# DRB CASE ACTION LOG

DRB Application No.: 11DRB-70040 Project # 1008691  
 Project Name: University Heights Addition  
 Agent: Surv-Tek Inc. Phone No.: \_\_\_\_\_

**CITY OF ALBUQUERQUE  
PLANNING DEPARTMENT  
March 2, 2011  
DRB Comments**

**RE: Lots 1-8, Block 4, University Heights Addition**

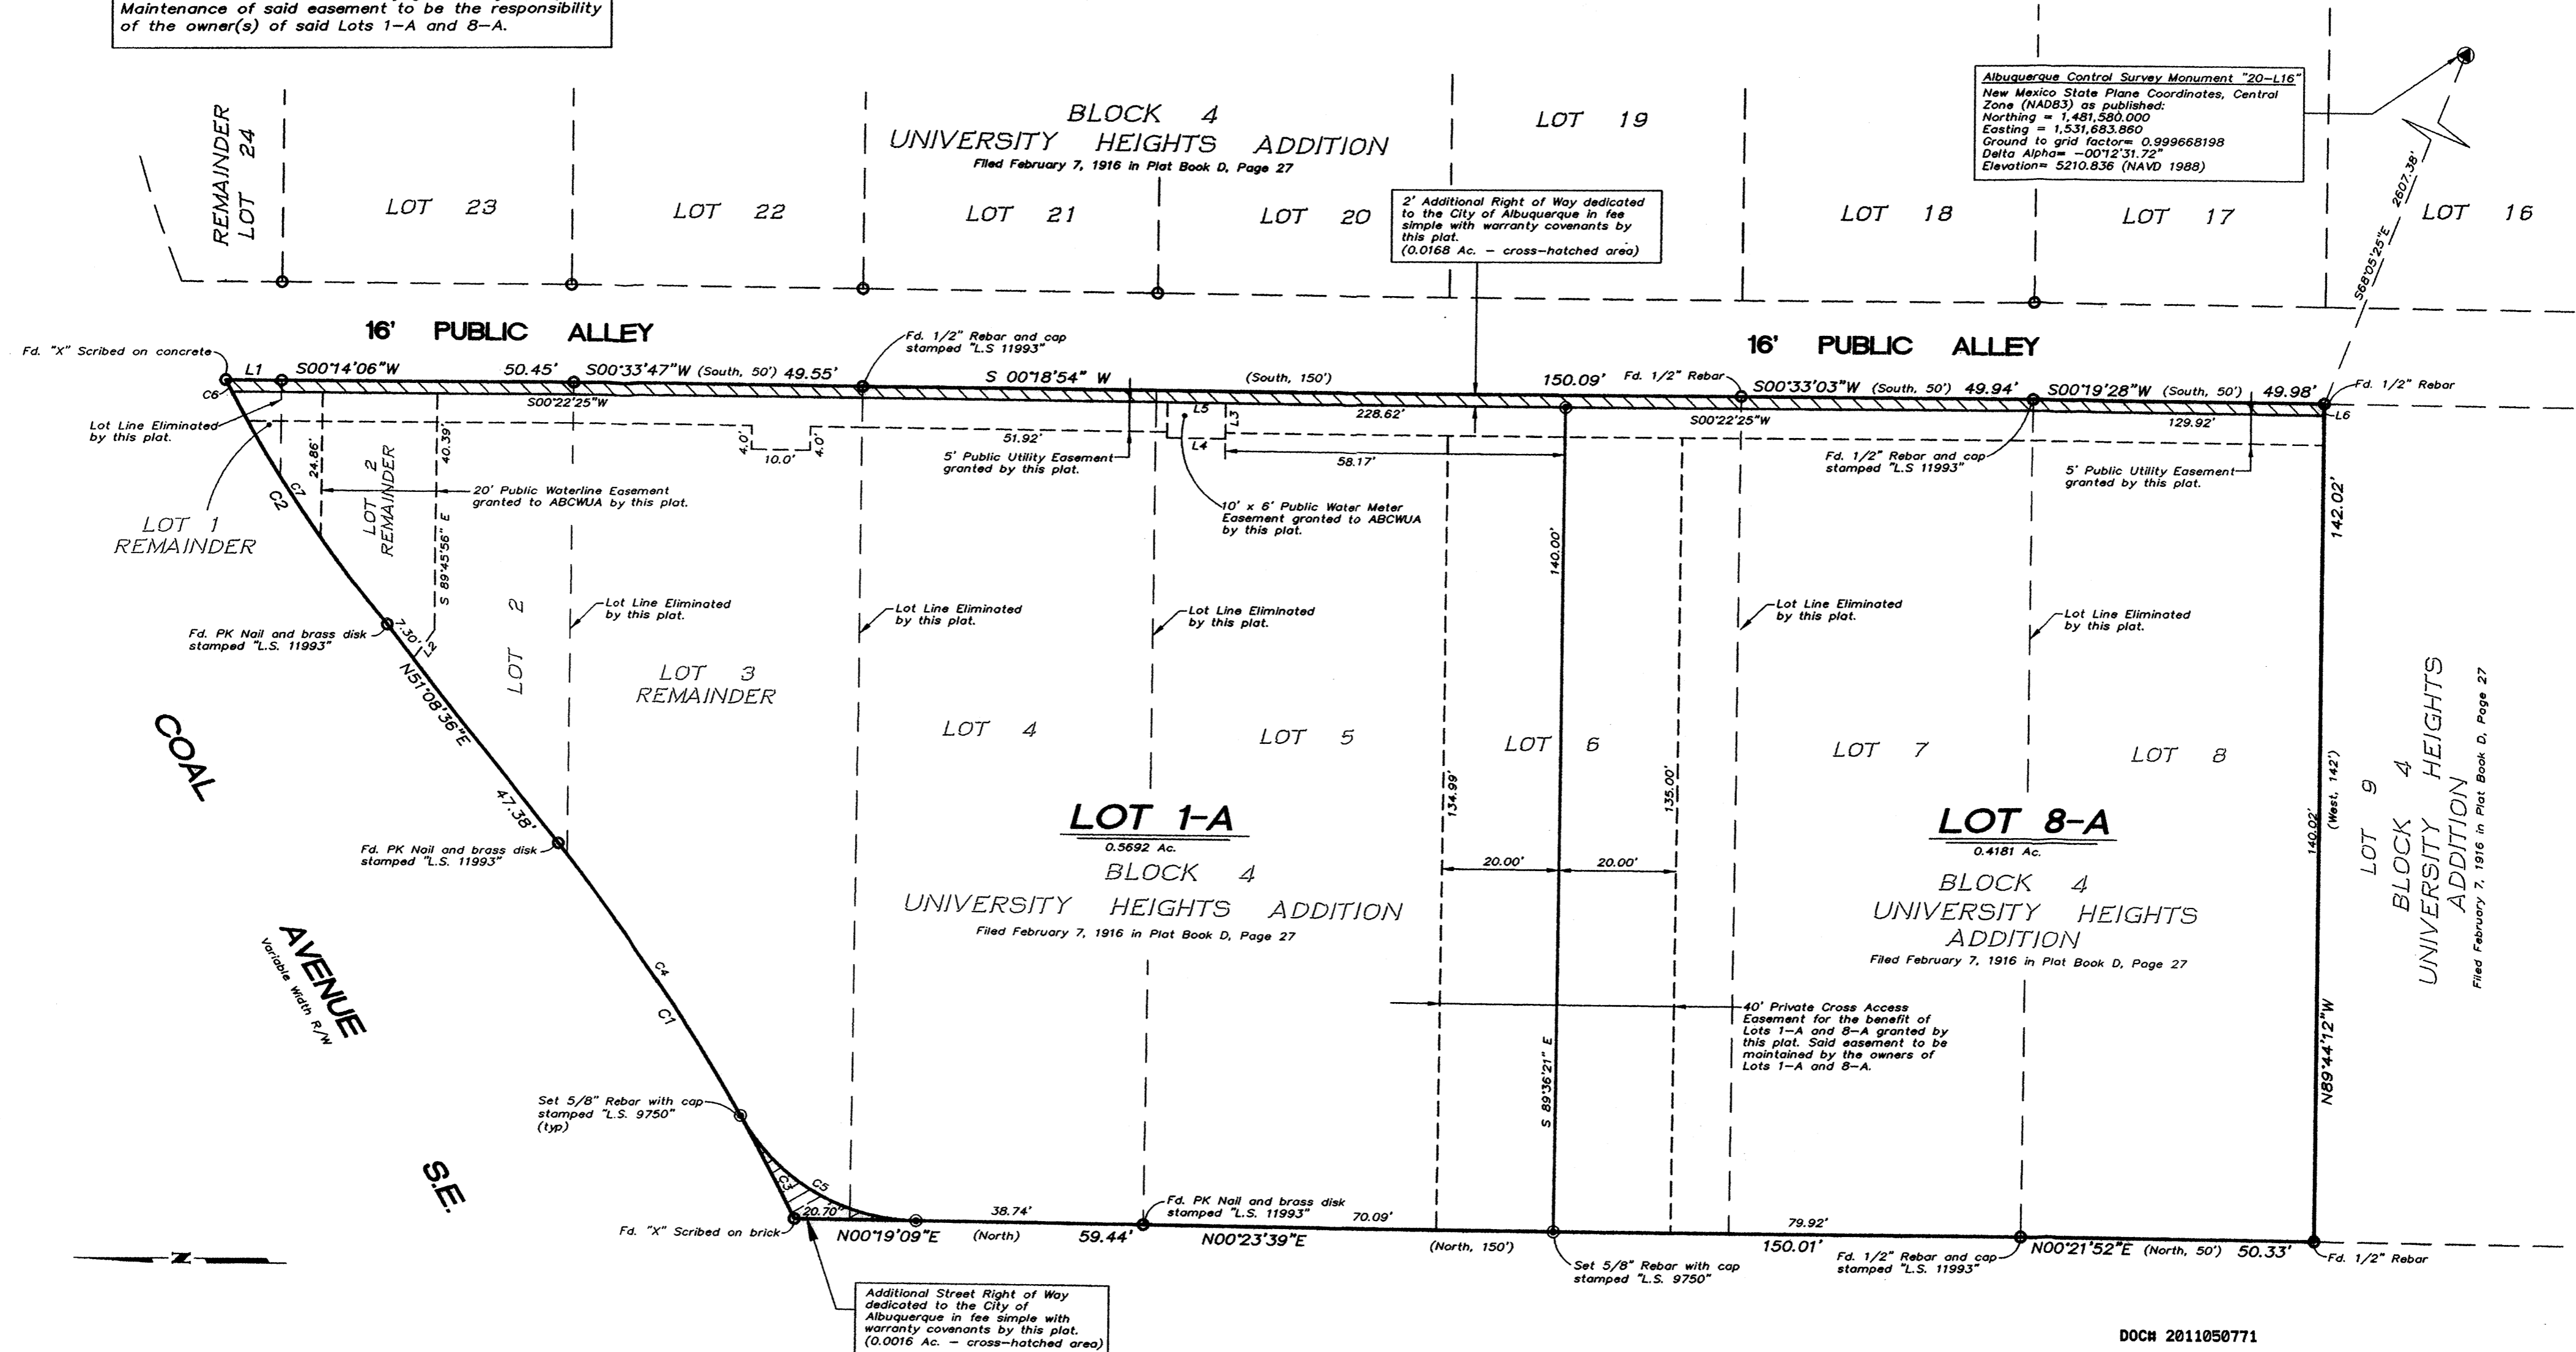
PLANNING (Last to sign): *- remove encroachment*  
*- update owner acknowledgment*  
*- l.d.x*

Prior to filing the final plat, encroachments within the 40 foot access easement must be removed.
